**Our ref:** ENVPAC/WTHAMS/00432  
(WA/2017/124029/01-L01)

**Date:** 27 June 2017

**The proposed development, includes the construction of a business park comprising between 55,000 and 60,000m2 office use (B1), parking for approximately 2,000 cars, associated highway, infrastructure and earthworks.**

**Bicester Office Park, Oxfordshire, OX26 1DE**

Drawing Number
1105_P_005

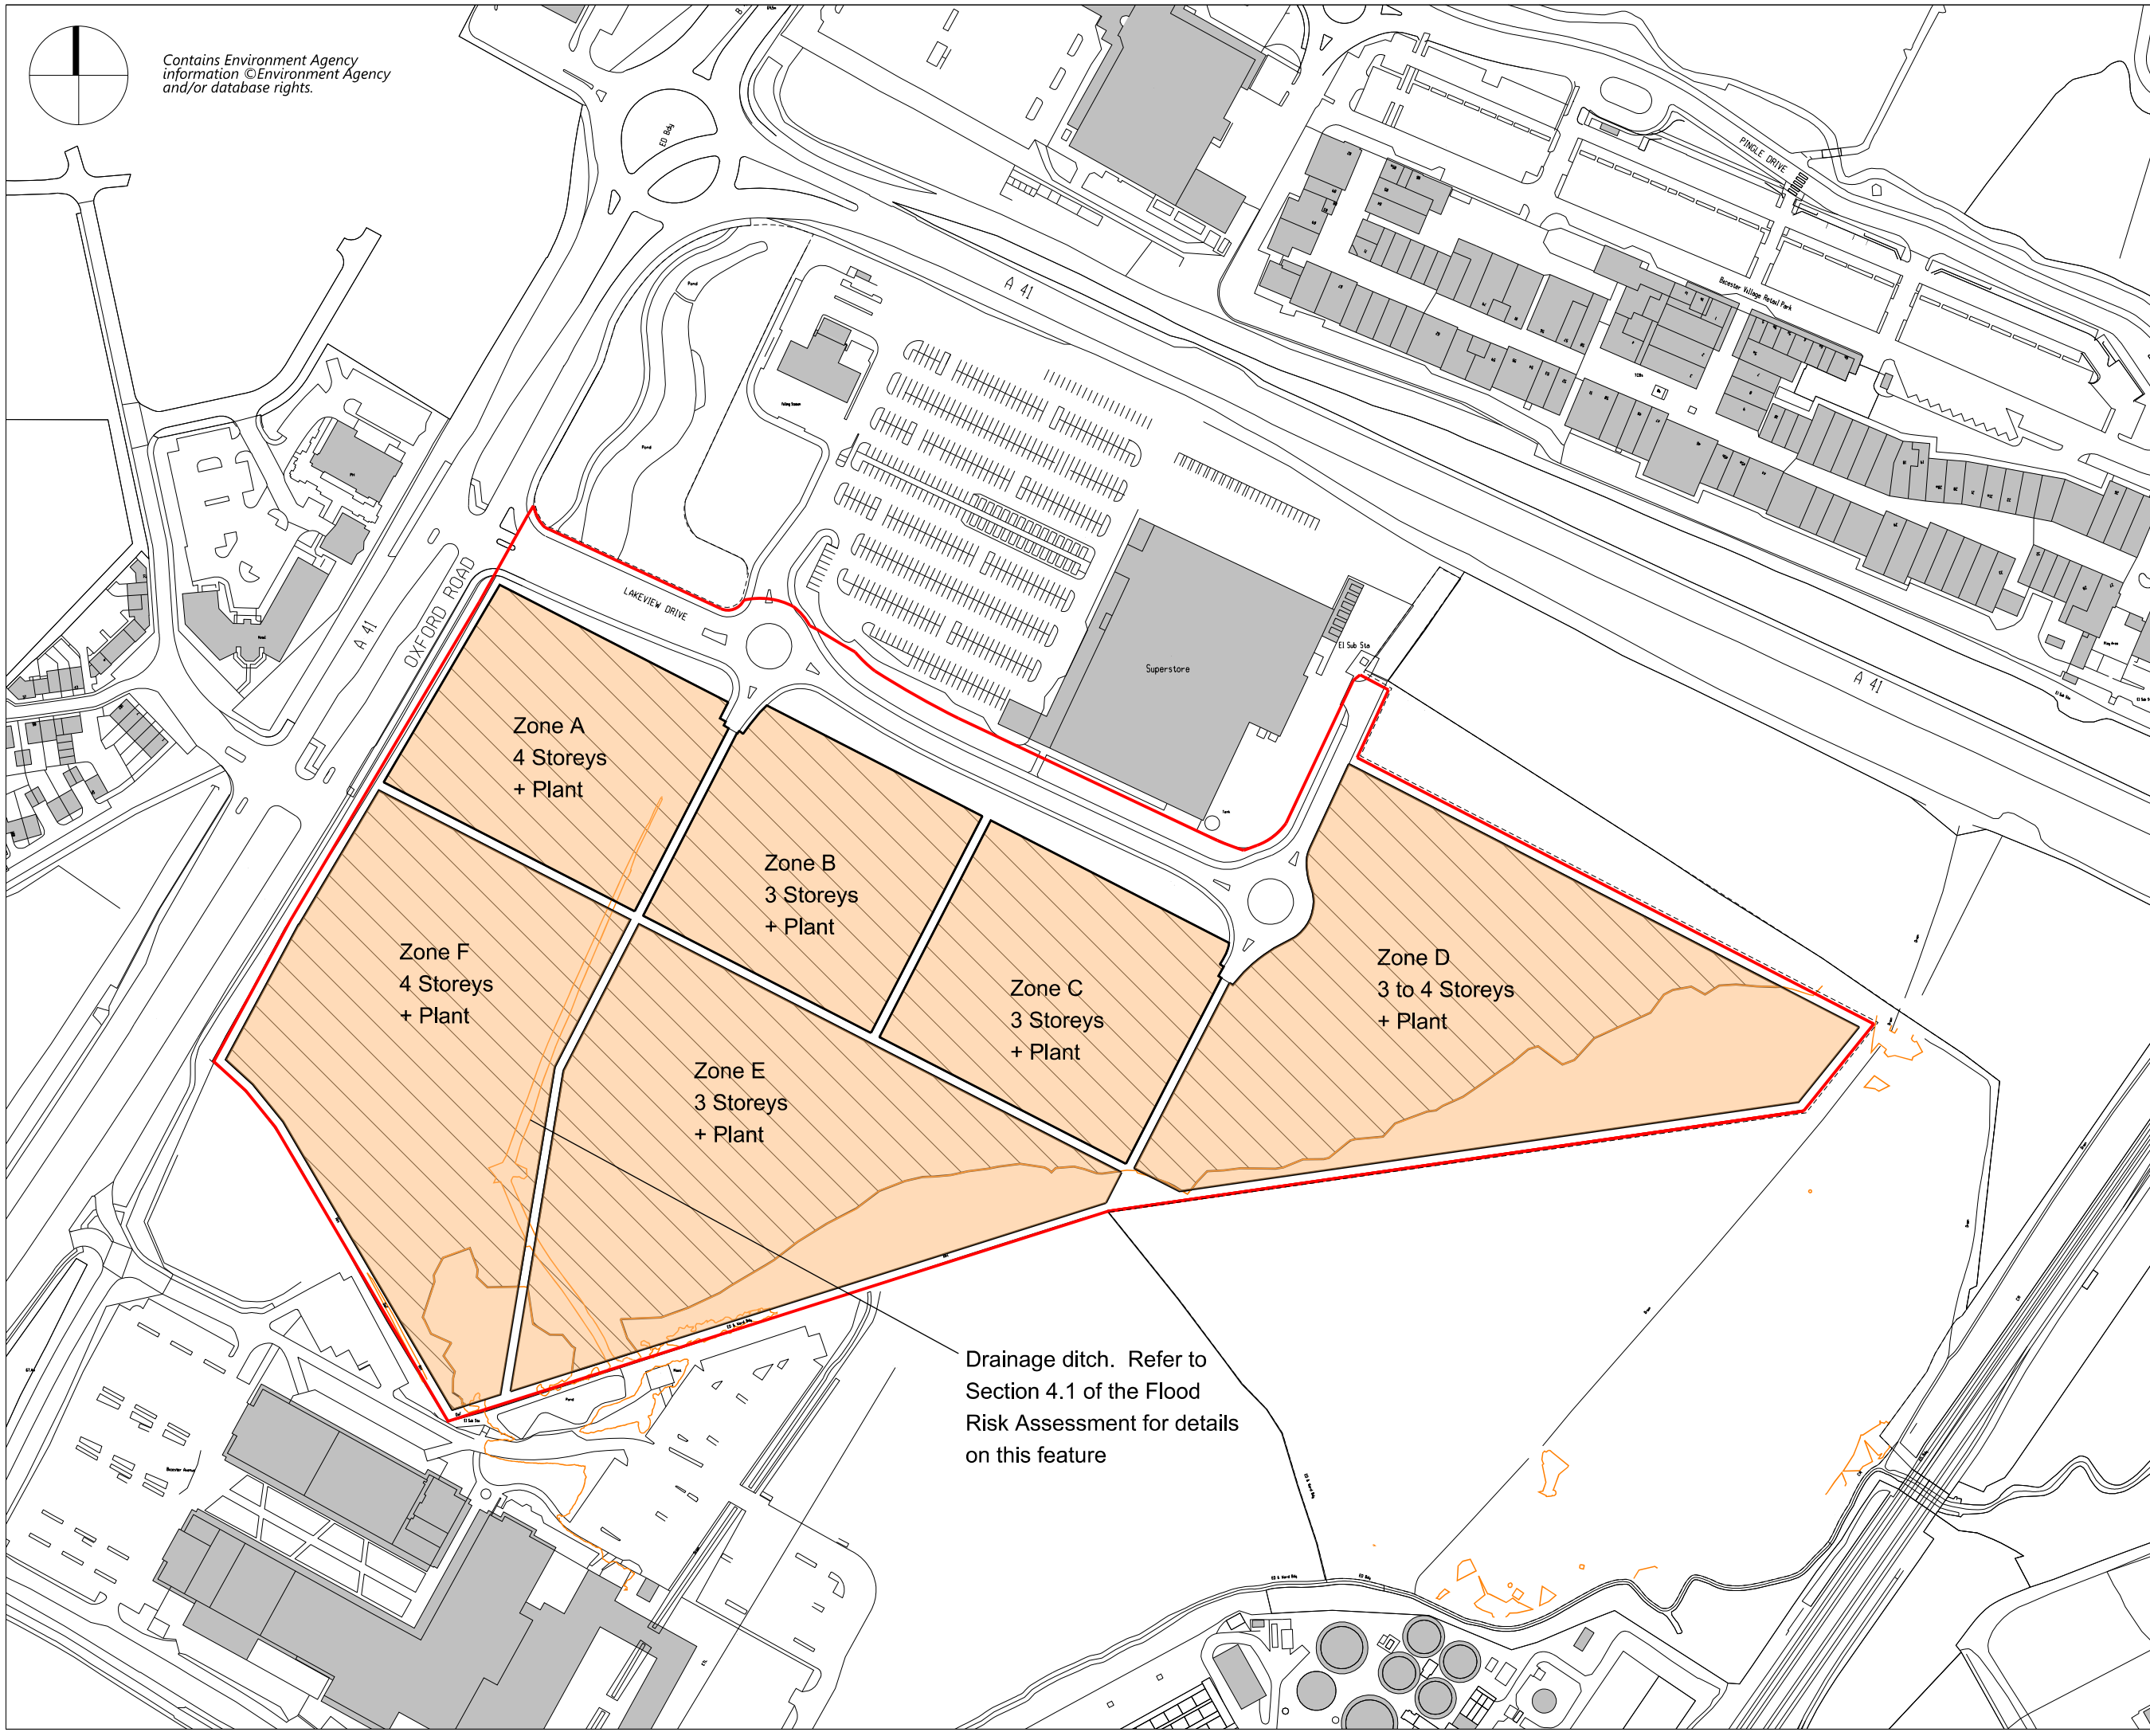
To ensure that Policy Bicester 4 clearly states that a sequential approach should be followed and that where possible buildings should be located away from the highest risk of flooding. We are pleased to see from the drawings you have provided that no buildings are proposed within the 1 in 20 (functional floodplain) extents. We would accept car parking within this area of highest risk providing that there was no raising of ground levels.

However, we would expect that a sequential approach is taken to ensure that no built development is located in areas up to the 1 in 100 year plus climate change (plus 35%) flood level. We note that you have carried out an intermediate assessment to establish a new climate change level and then mapped it on a topographic survey. This shows buildings located in the 1 in 100 year plus climate change (plus 35%) flood extent which we feel is not in line with the principles of Bicester Policy 4.
